Planning Officer: Mrs A Gardner

Planning Application Ref: R/230/19/PL

Location: Springfield House, Springfield Close, Rustington, BN16 2SZ

Description of works: 1 No. dwelling and swimming pool (part resubmission following R/91/17/PL & R/204/18/PL).

Drawing No Status Revision
181303/10 A

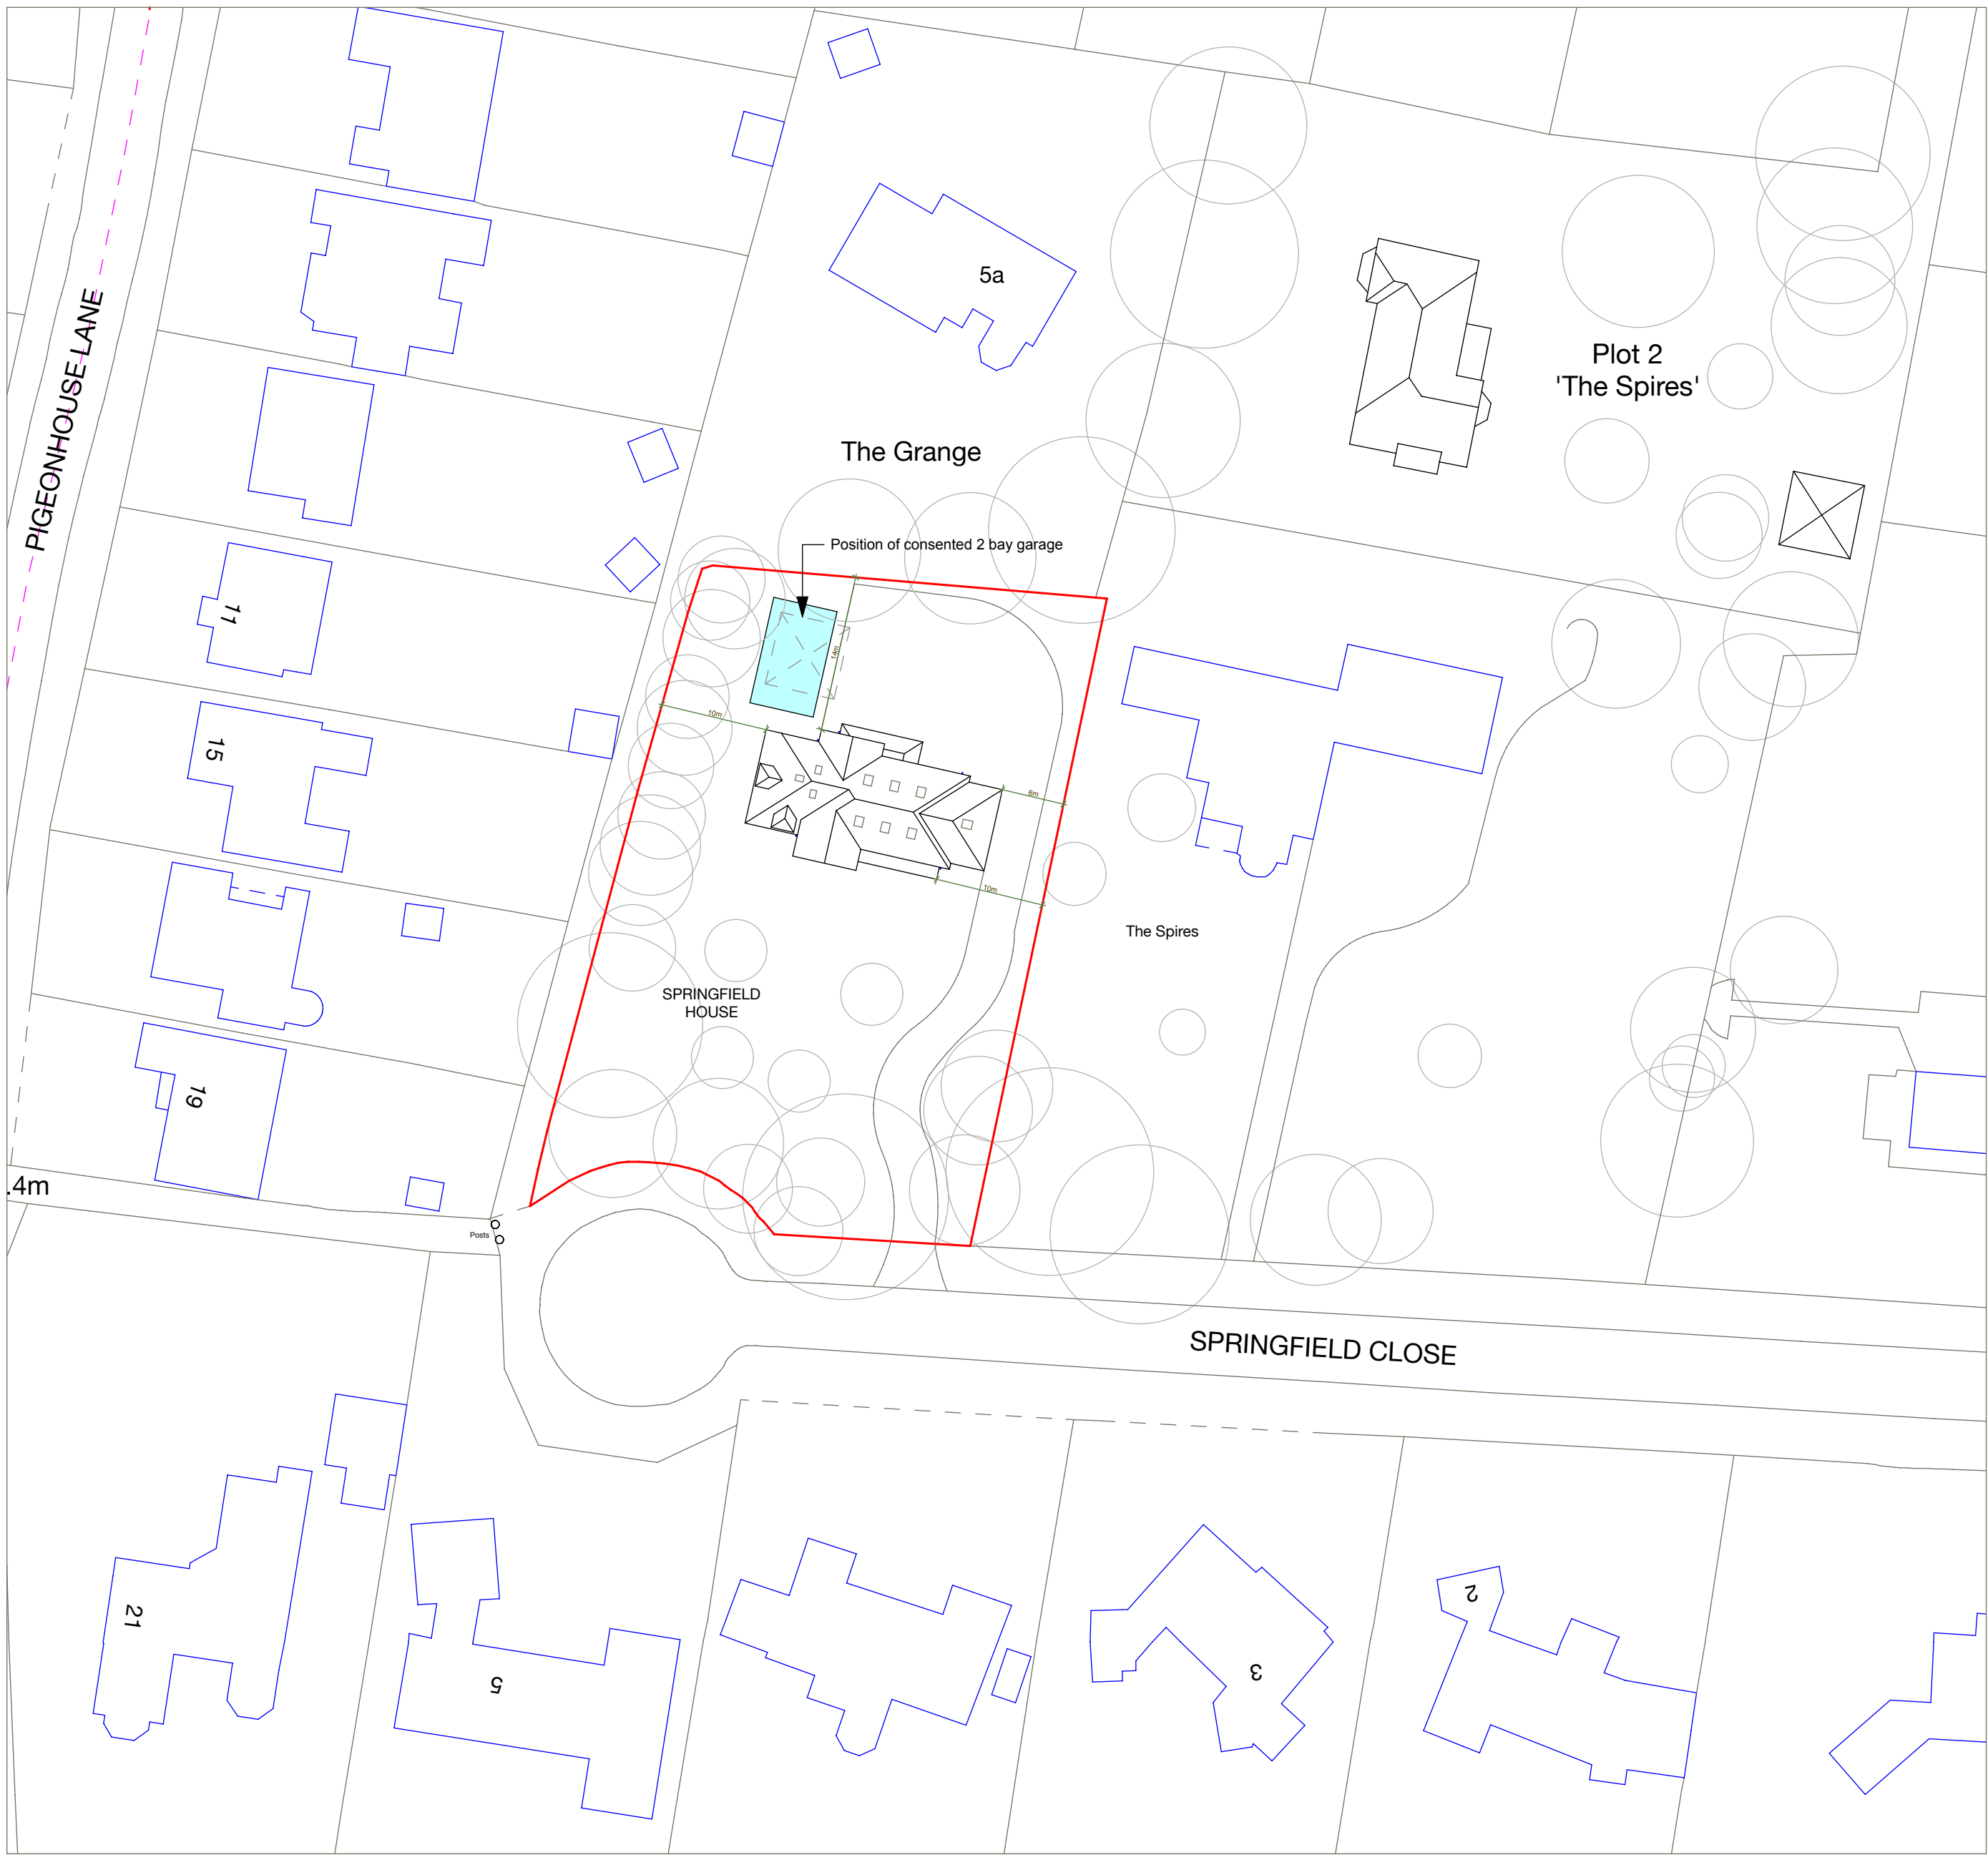
- The applicant has submitted an amended site plan, dwg. no. 181303/08, Rev A, Sept 19. Off-site trees to the north have not been accurately illustrated on this or previous versions of said plan; I have referred to the Tree Protection Plan, Arbortrack Systems Ltd in order to make a judgement on the likely impact of these proposals on retained trees. That said, the fundamental amendments to the proposal seem clear:

- The 3-bay garage has been removed, the pool is retained.
 - The area of hardstanding for driveway/parking now extends slightly into the area previously identified for the garage footprint and more importantly the RPA of off-site tree T17.

- The area of 'no-dig' construction within the hardstanding needs to be extended further across RPA of T17.
